# PORTLAND MAINE

Job ID: 2011-05-1142-ALTR

Re: 102 Vermont Avenue – 405A F038 – build 10' x 12' screened house – permit #2011-05-1142

Plot Plan

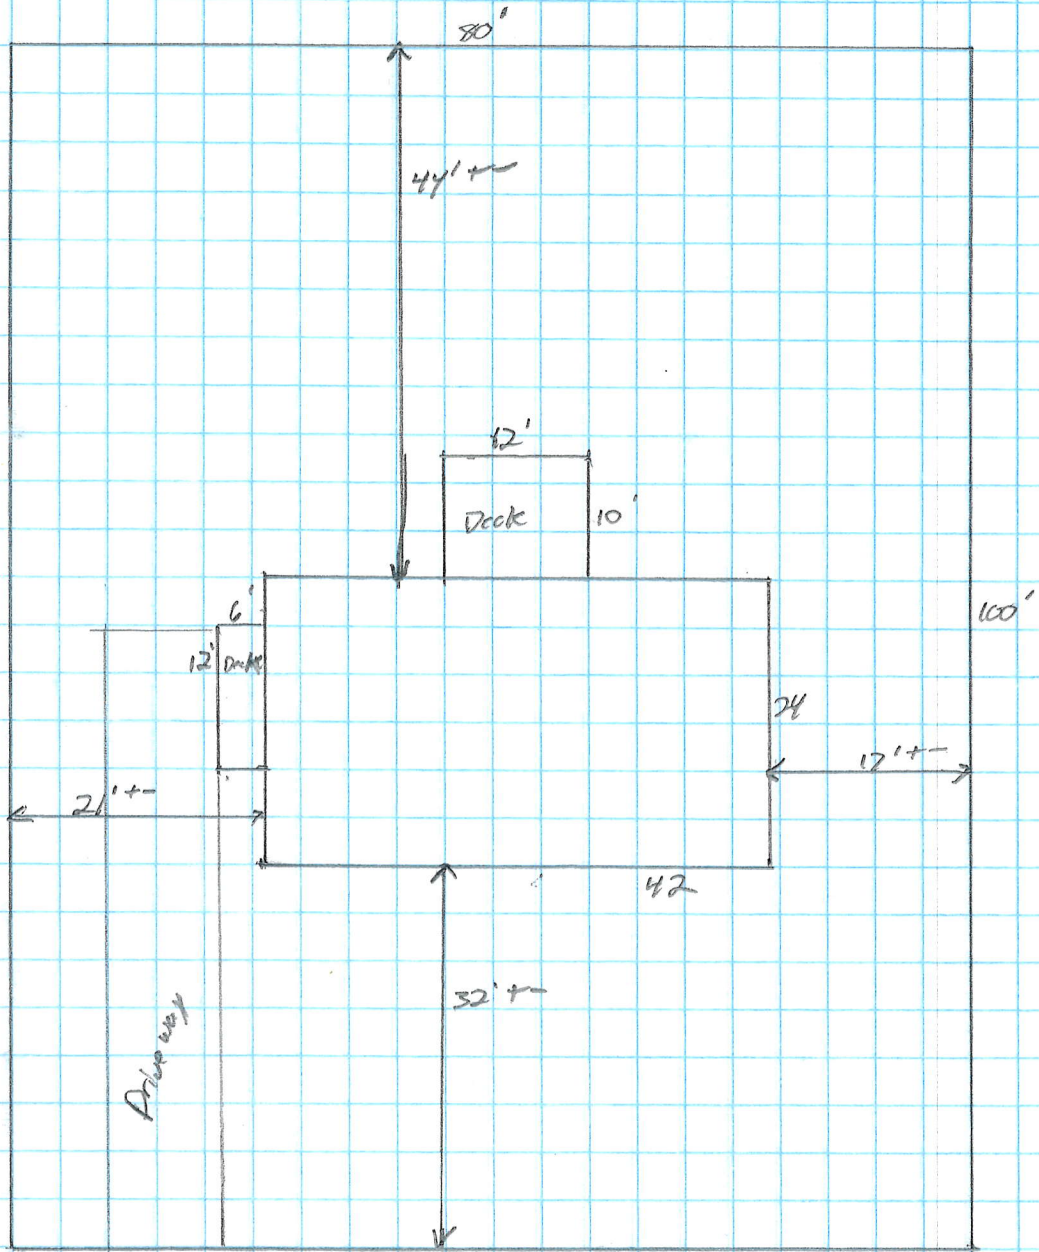
I have reviewed your application to build a ten foot by twelve foot screened house at your property at 102 Vermont Street. At this point your application cannot be approved because the proposed structure does not meet the required rear and side setbacks. I tried to call you to inform you of this, but your phone just rang and rang. I did leave a voicemail with your contractor, Michael Davis.

Your property is located in the R-3 residential zone. The required side setback and rear setback for an accessory, detached structure that is 144 square feet or less is five feet [section 14-90(d)(2)(b) & (d)(3)(b)]. The plot plan gives the rear setback as four feet and the side setback as four feet. You need to revise your plot plan to show that the rear and side setbacks are a minimum of five feet. The permit is on hold until the required setbacks are being met.

1. This permit is being approved on the basis of plans submitted. The new structure must be a minimum of five feet from the rear and side property lines as shown on the revised plot plan. Any deviations shall require a separate approval before starting that work.
2. This property shall remain a single family dwelling. Any change of use shall require a separate permit application for review and approval.
